I am writing to comment on planning application 2023/93667 relating to the redevelopment of Storthes Hall student village into 261 dwellings. As a local resident I support the redevelopment of the site into housing, it is much preferable to the site becoming dilapidated or simply demolished. However, I have the following concerns that I would like Kirklees planning to consider before granting permission.

Tree Retention Plan - Scale 1:1000

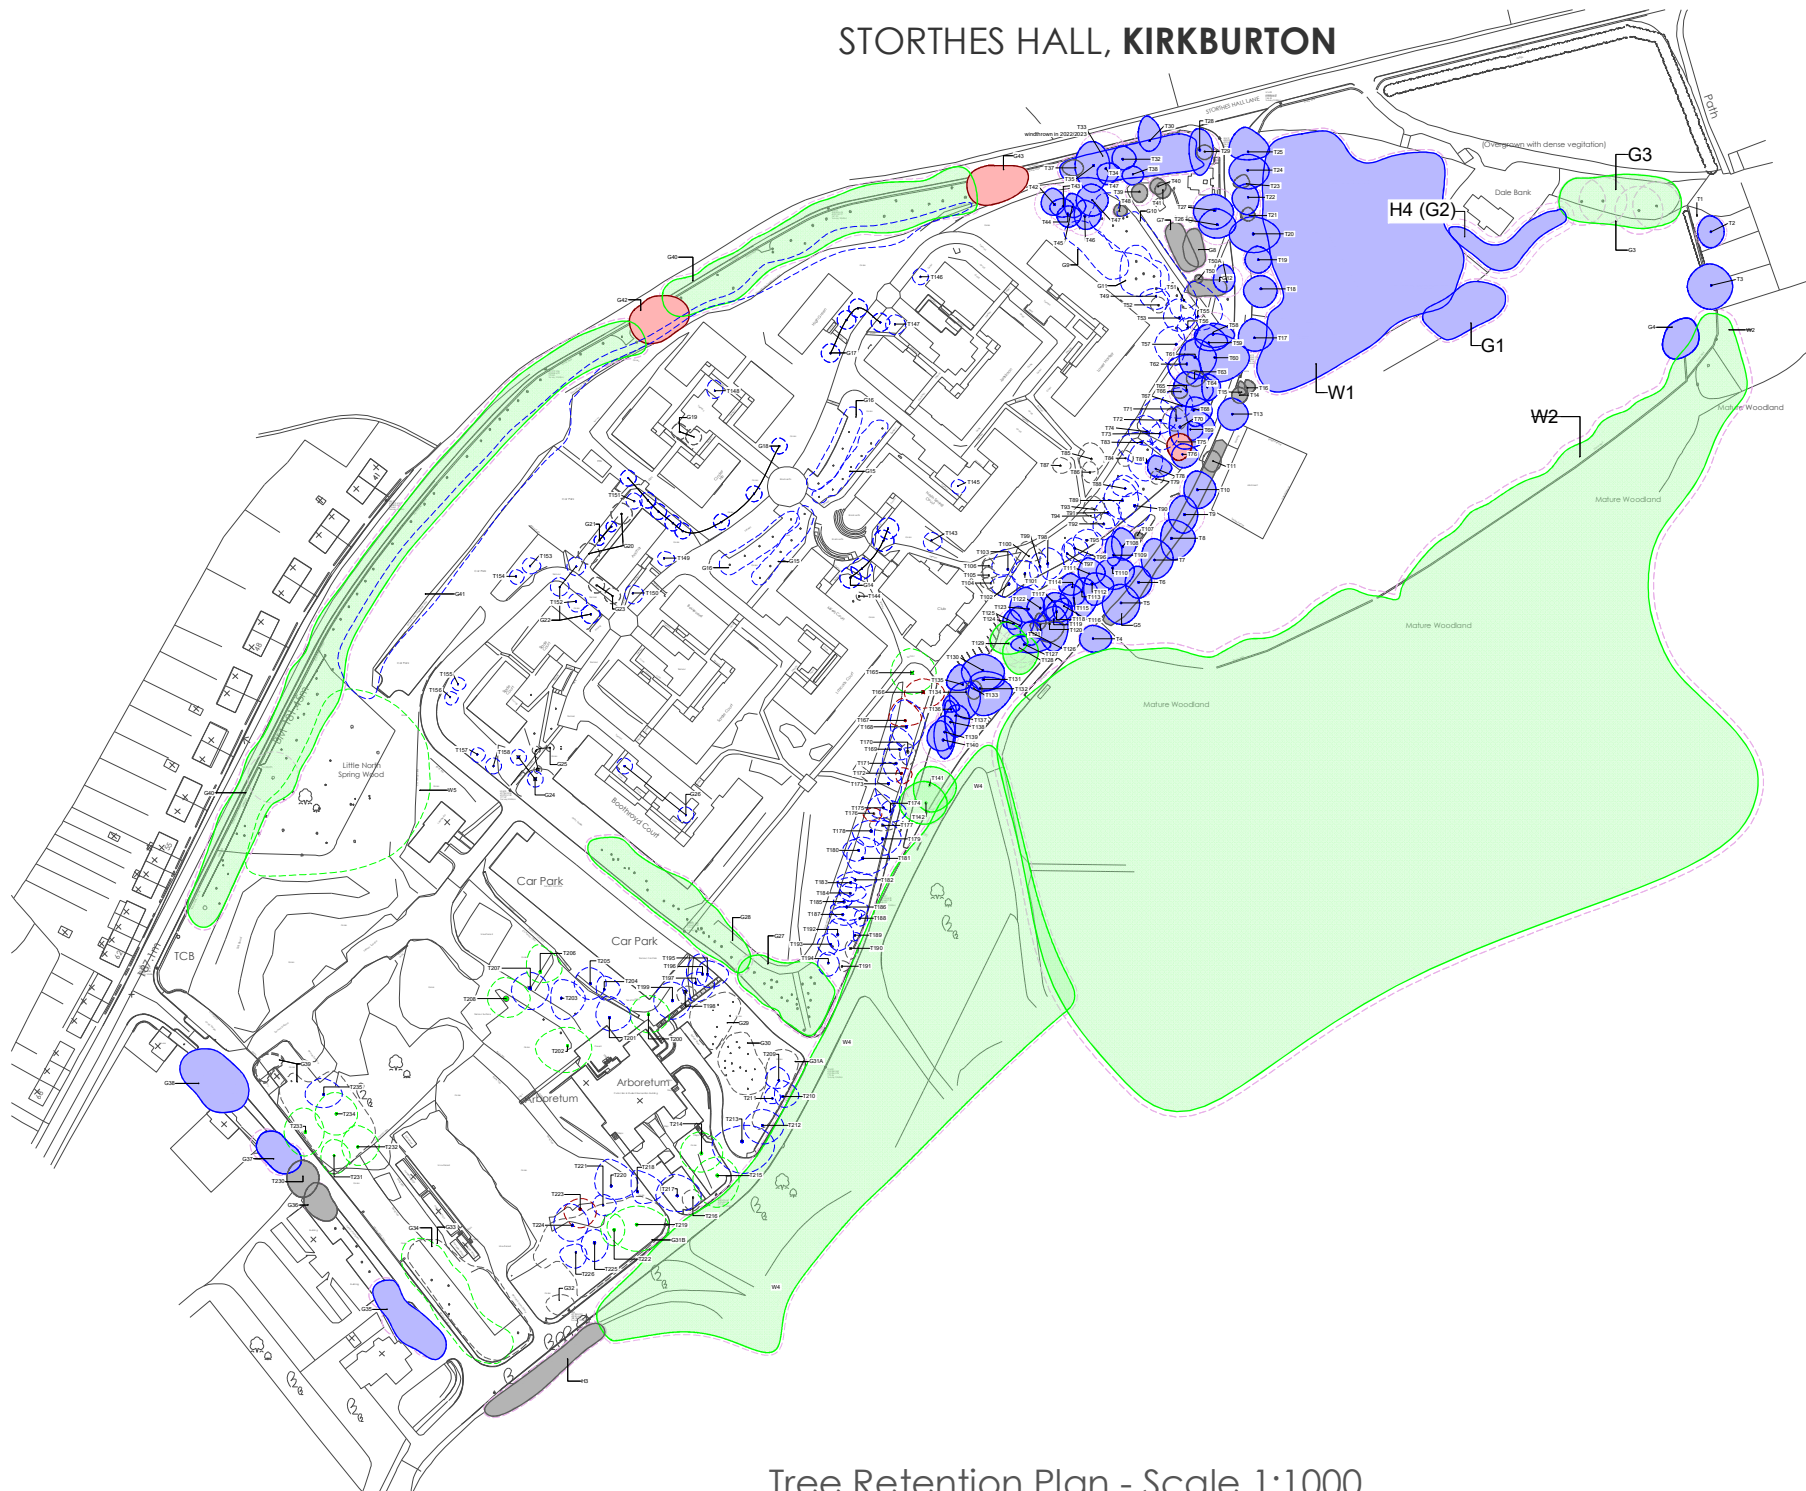
Biodiversity. I am alarmed by the apparent significant reduction in size of Little North Spring Wood (labelled G40 on document ref. 1826-SI-05) and the resulting removal of mature trees (including oak, beech, sweet chestnut, horse chestnut and hazel) and their valuable under-canopy that greatly contribute to the biodiversity of the site. These mature woodlands should be retained at their current size and the plans adapted accordingly, with less, lower density housing if necessary to meet biodiversity improvement requirements. Additionally, the existing site already has a huge range of biodiversity from the mature shrubs, hedges, trees and grasslands which will be removed during redevelopment; it is questionable that replacing these valuable ecosystems with lawned gardens will meet the requirements for new developments to provide a biodiversity net gain of 10%. Kirklees planners and the developers should note that the proposal to retain the patch of fir woodland (labelled W1 on document ref. 1826-SI-05) would be much more suitable to remove to build houses since this monoculture of fir has lower biodiversity value than native mixed woodland and mature trees throughout the site.

Site Layout Plan - Scale 1:1000

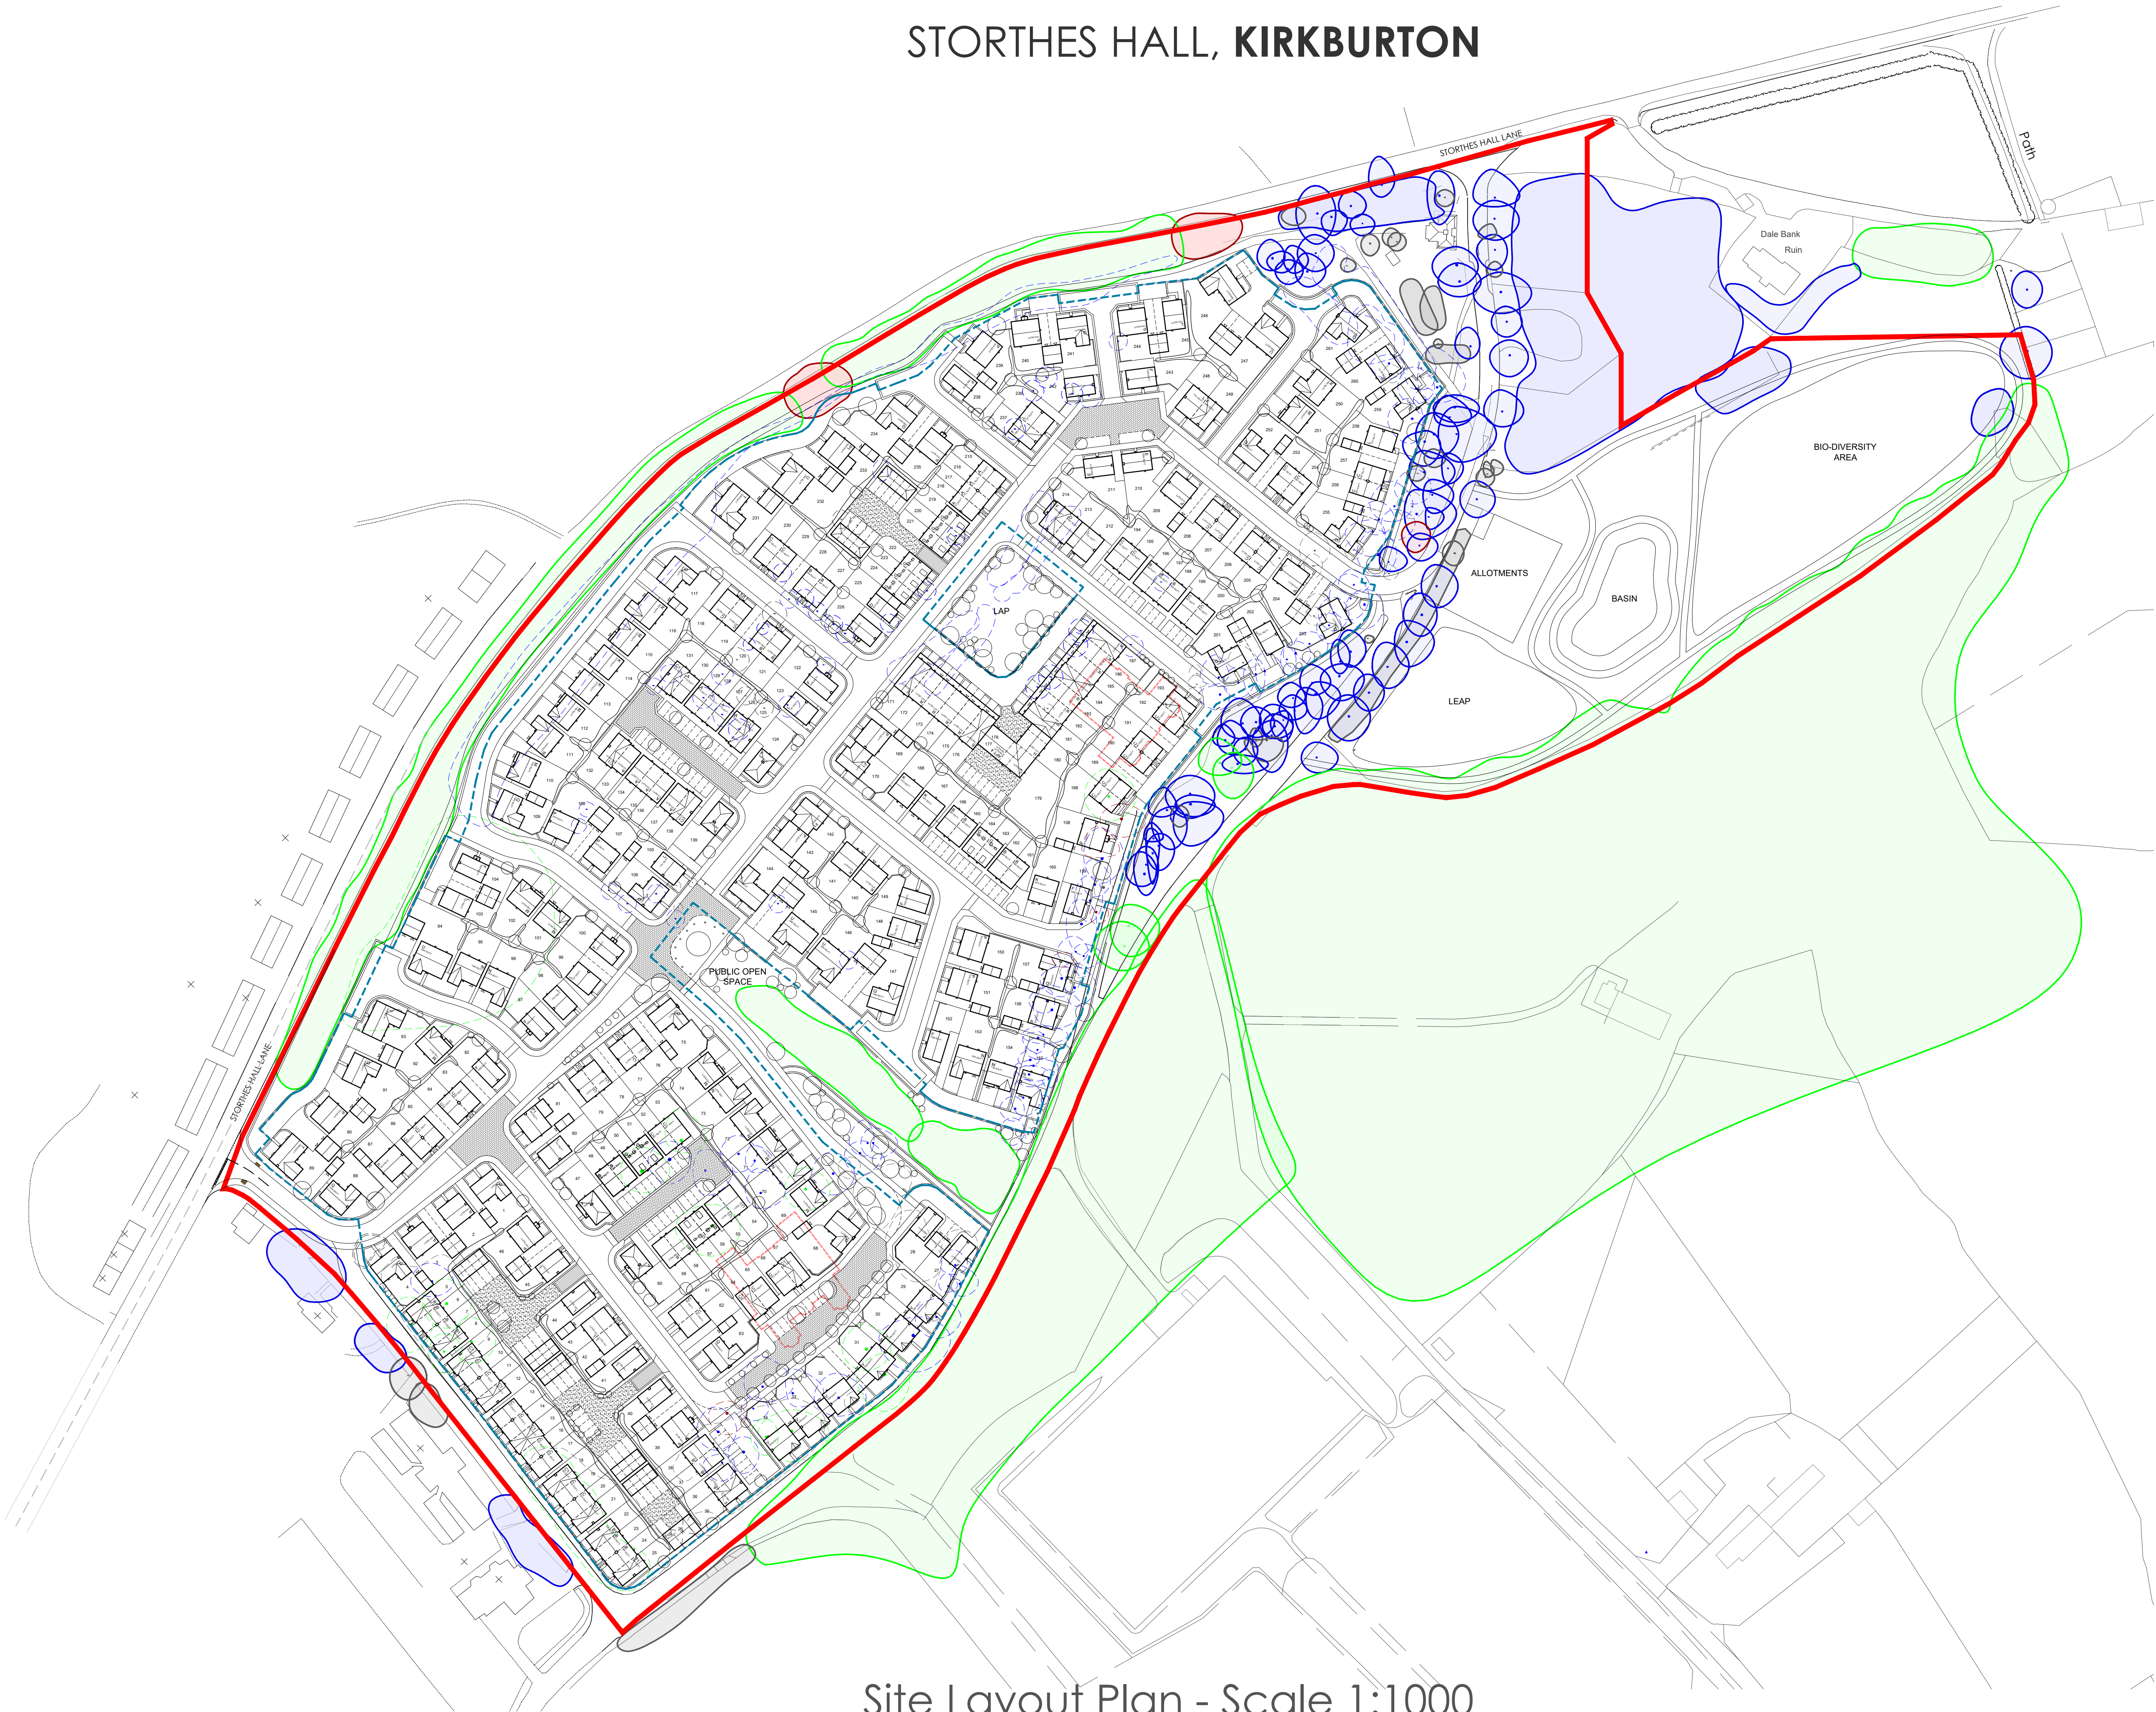
New estate road layout and dangerous upper exit. The proposed road layout should be revised to encourage traffic to use the lower entrance further down Storthes Hall Lane. At the upper entrance speeding traffic and parked cars reducing visibility have resulted in a lot of near misses recently. Reducing the road speed to 30 would improve this but encouraging traffic to use a newly bi-directional entrance/exit at the current lower entrance where there is improved visibility and more space for traffic would improve road safety and reduce the impact on existing residents.
